Scorton, 9 Lime Tree Close, East Preston, BN16 1JA

EP/52/18/PL

Demolition of existing dwelling & the erection of 7No. residential dwellings, with associated parking, amended access location from Lime Tree Close & landscaping.

Response to objections V4: Lime Tree Close, East Preston. Application number EP/52/18/PL

Drawing ref: LT.SC 001

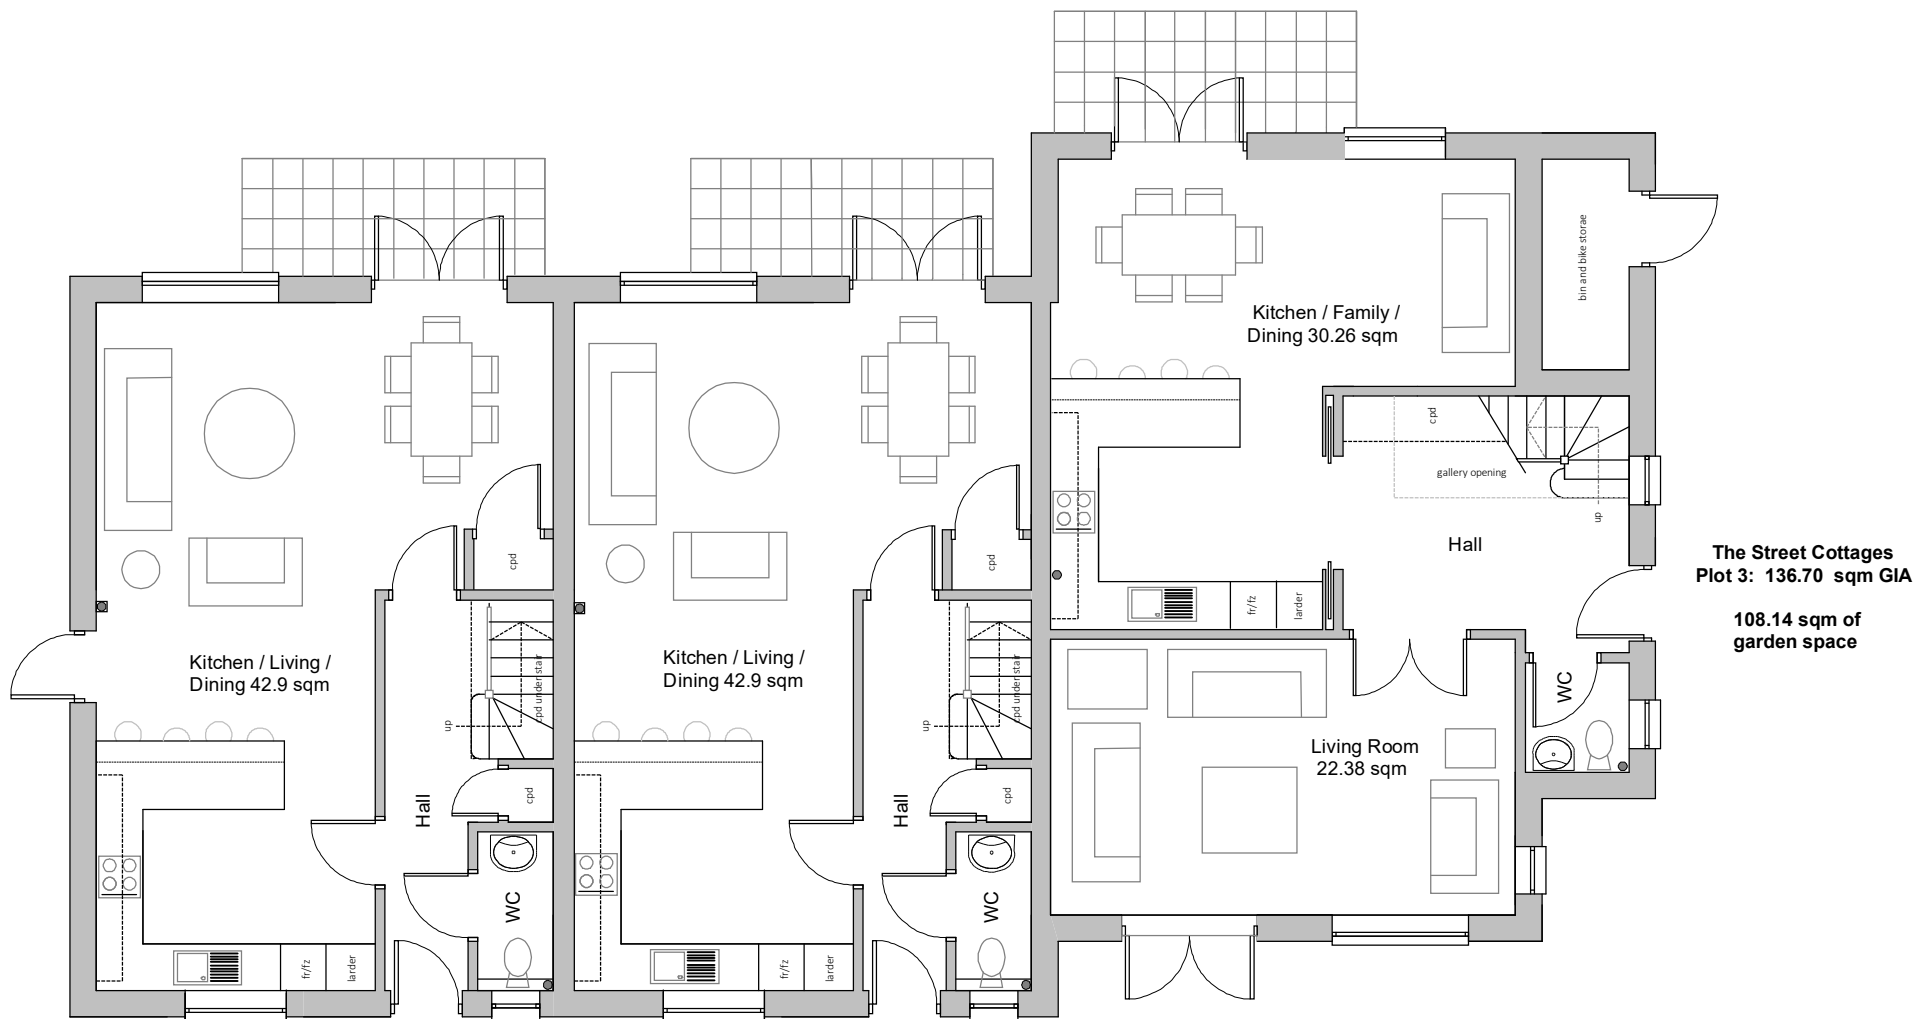
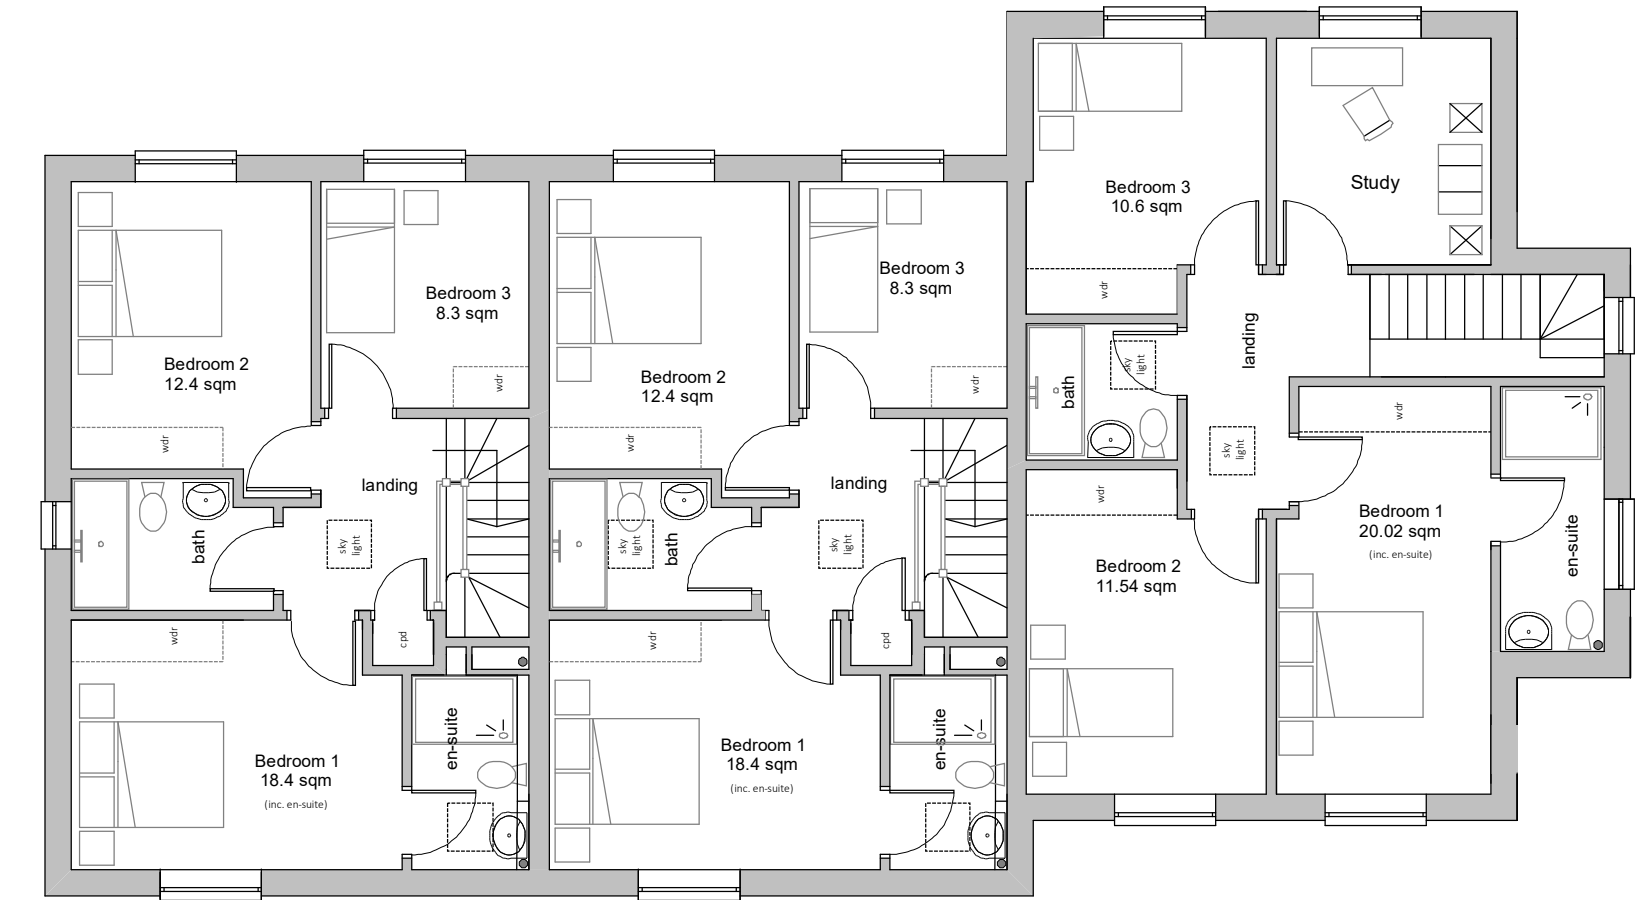
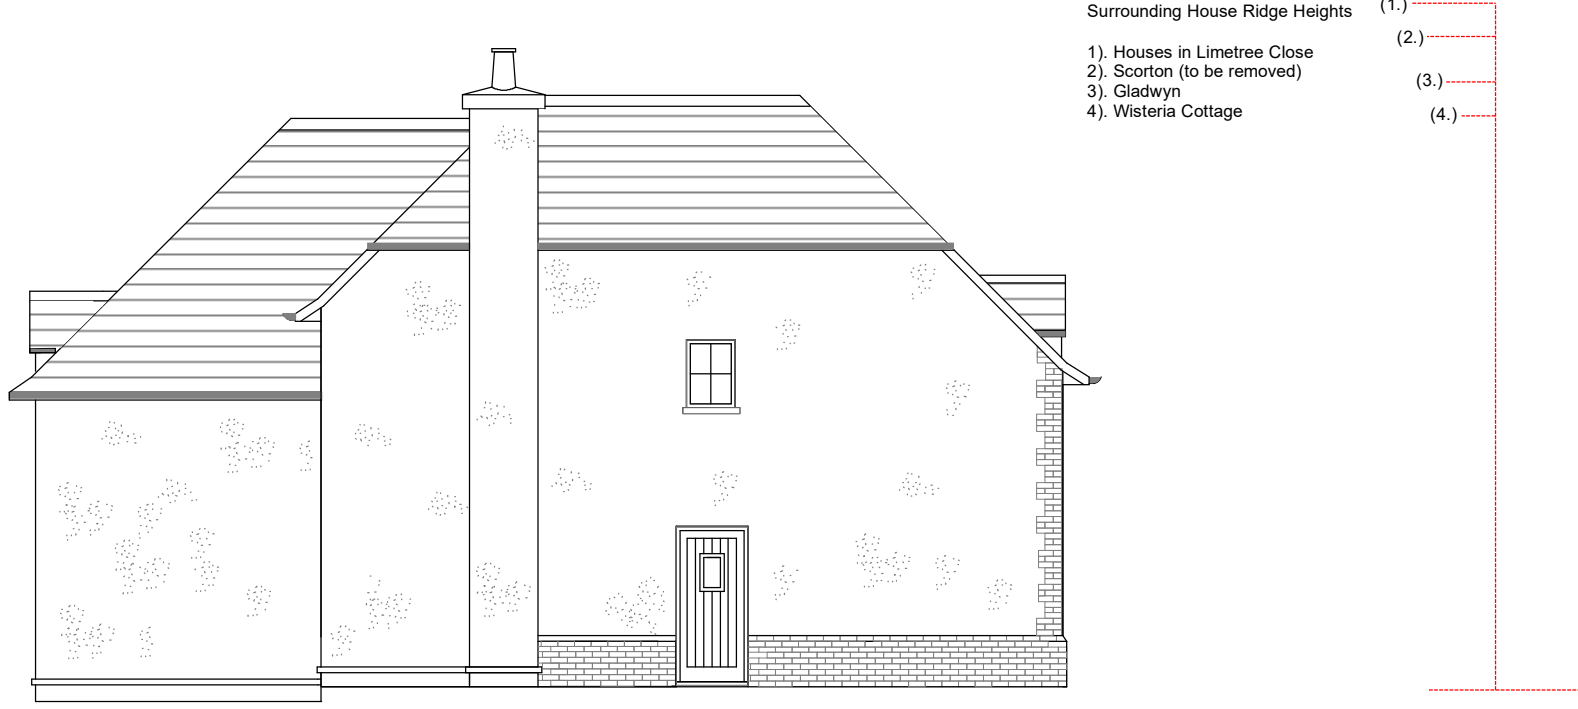
Centres on the view from Wisteria Cottage and the potential for overlooking from the first floor windows of Plot 3 into the garden space and bedrooms of Wisteria Cottage.

Although we believe the spacing is sufficient to ensure privacy, especially as the spaces in question directly open onto the highway and the two properties are separated by a road we have amended the drawing LT.SC.001 to LT.SC.0012 as follows:

Internal layout of plot 3 to have a none habitable room from bedroom 1 facing Wisteria Cottage and the window from this will be obscure glazed and with restricted opening.

Amendments:
Internal room layout bedroom 1 to provide none habitable room in plot 3 facing Wisteria Cottage.
Dimension added showing floor to ridge heights of Plot 3
Section of plot 3 showing roof void height.

Drawing ref: LTC.PLOT7.001

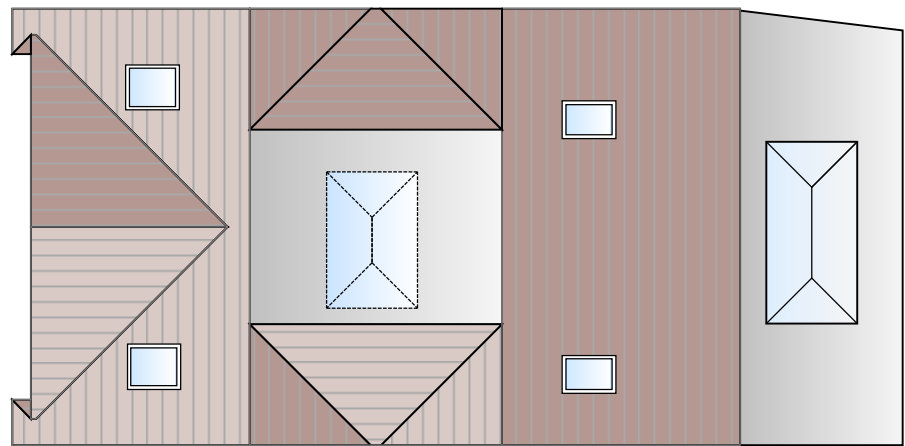
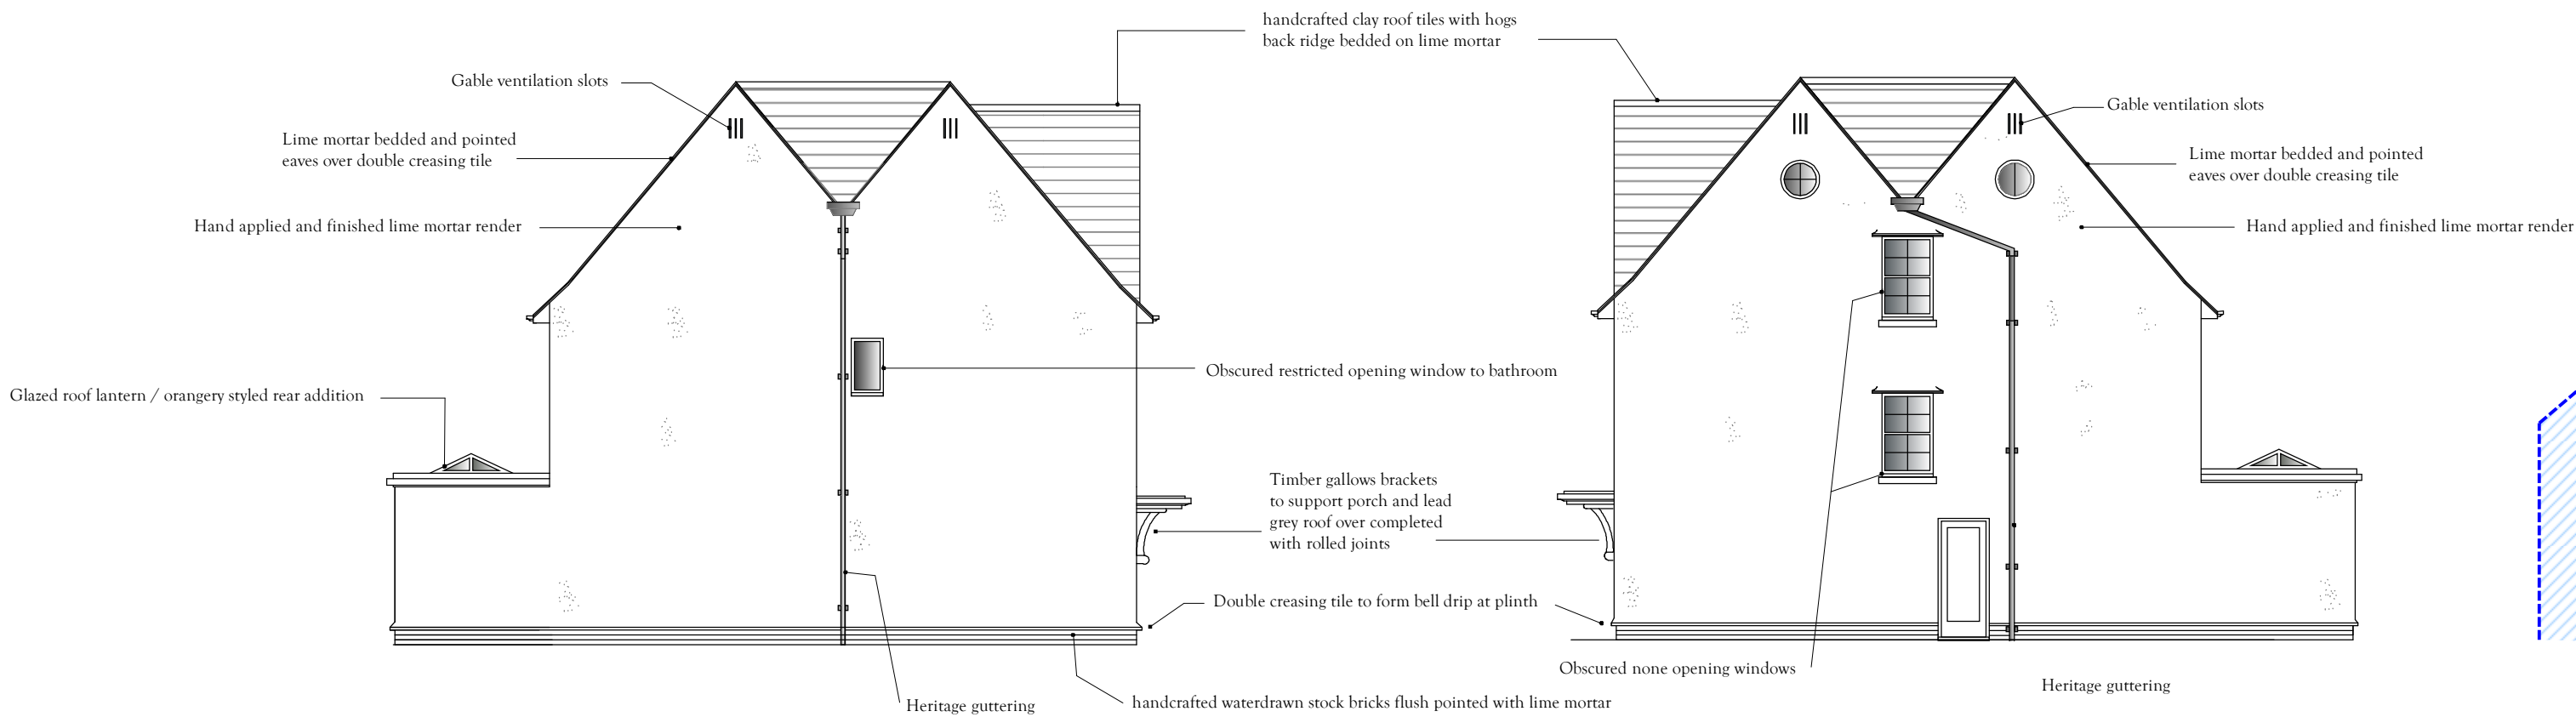
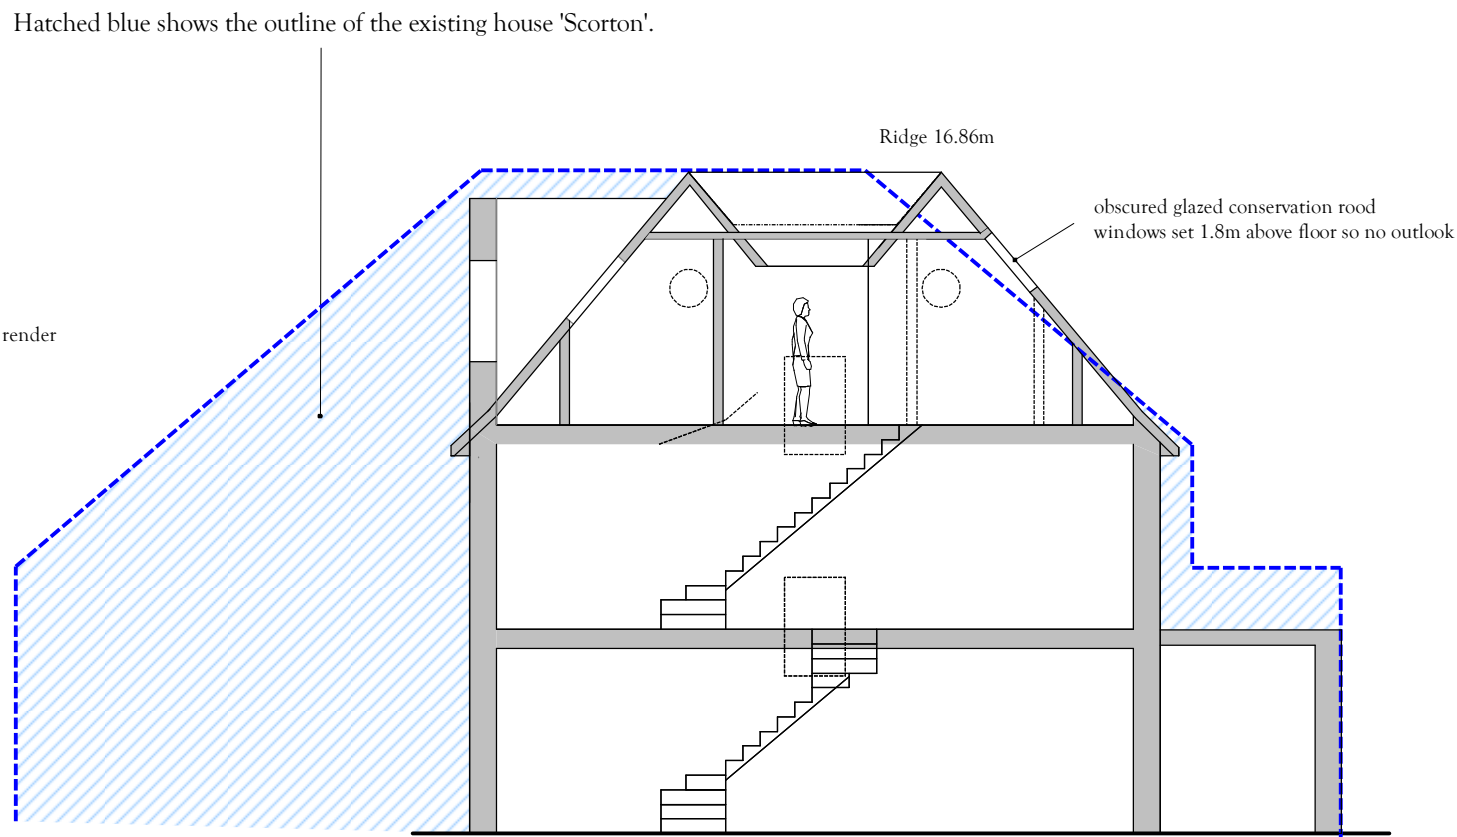
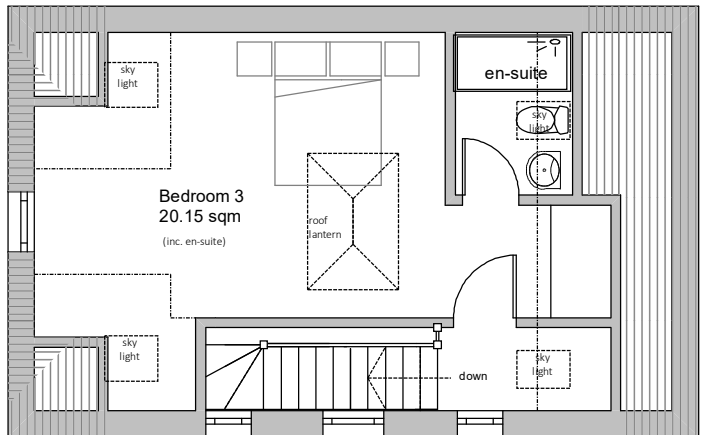
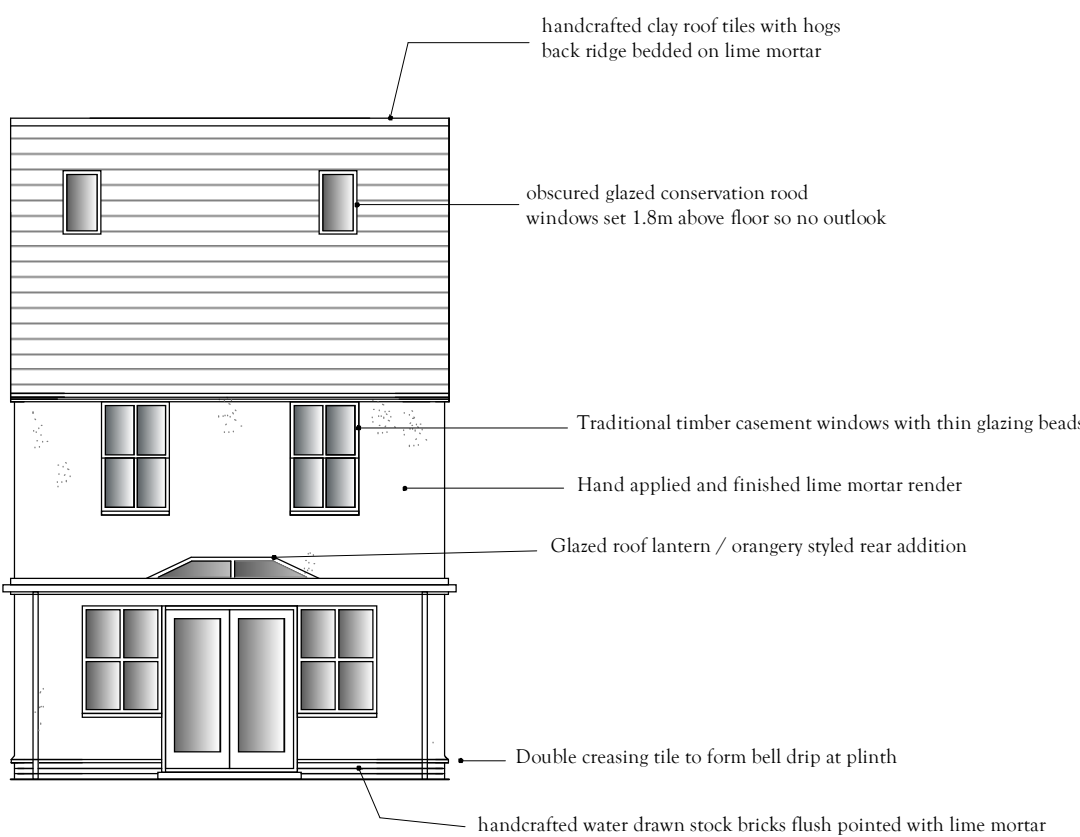
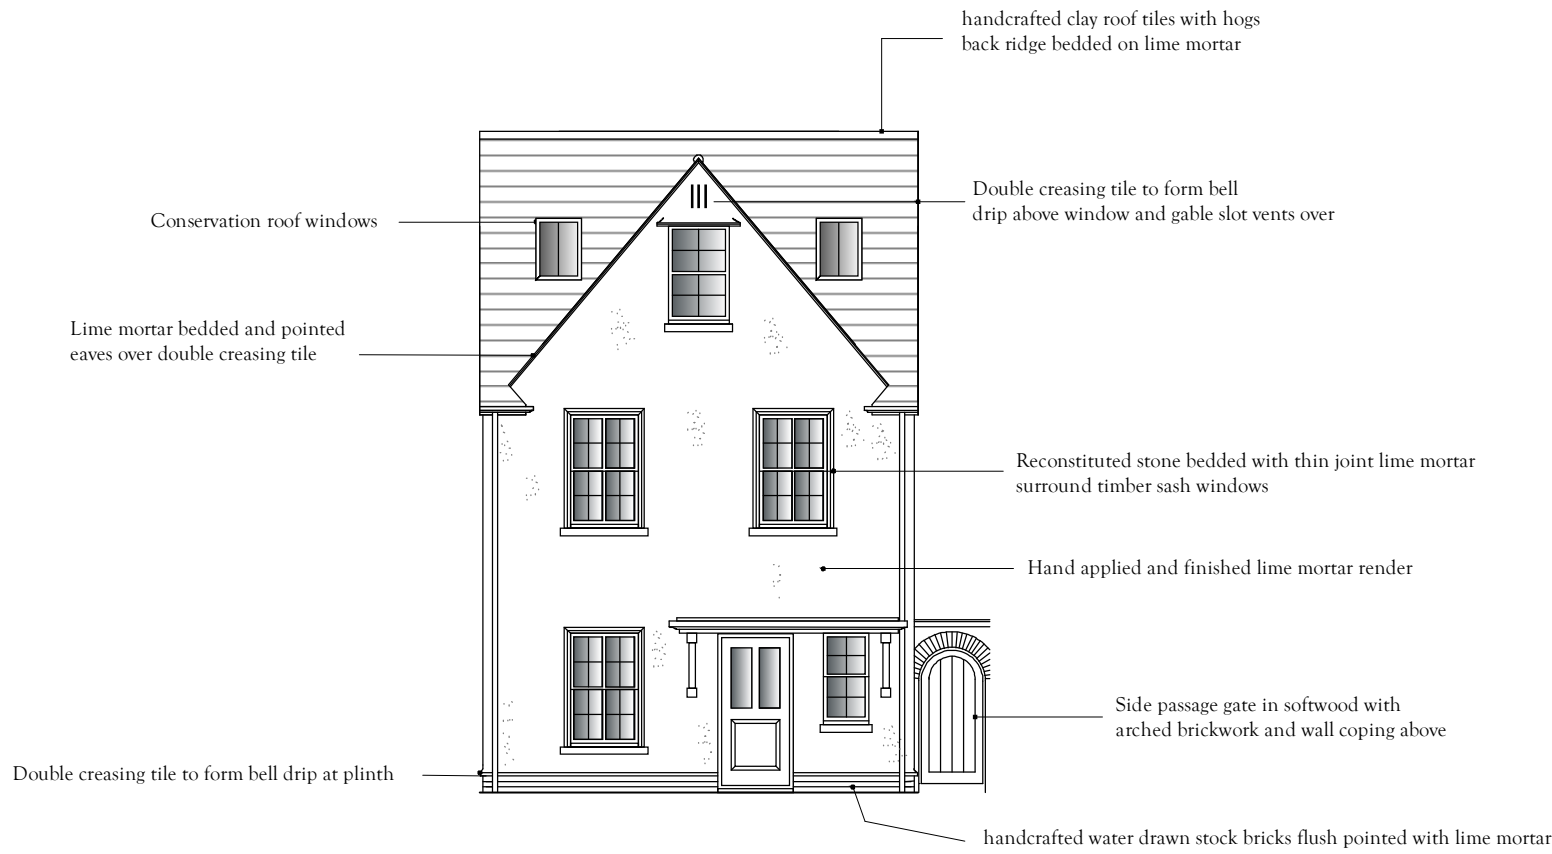
Amendments: East facing roof lights removed
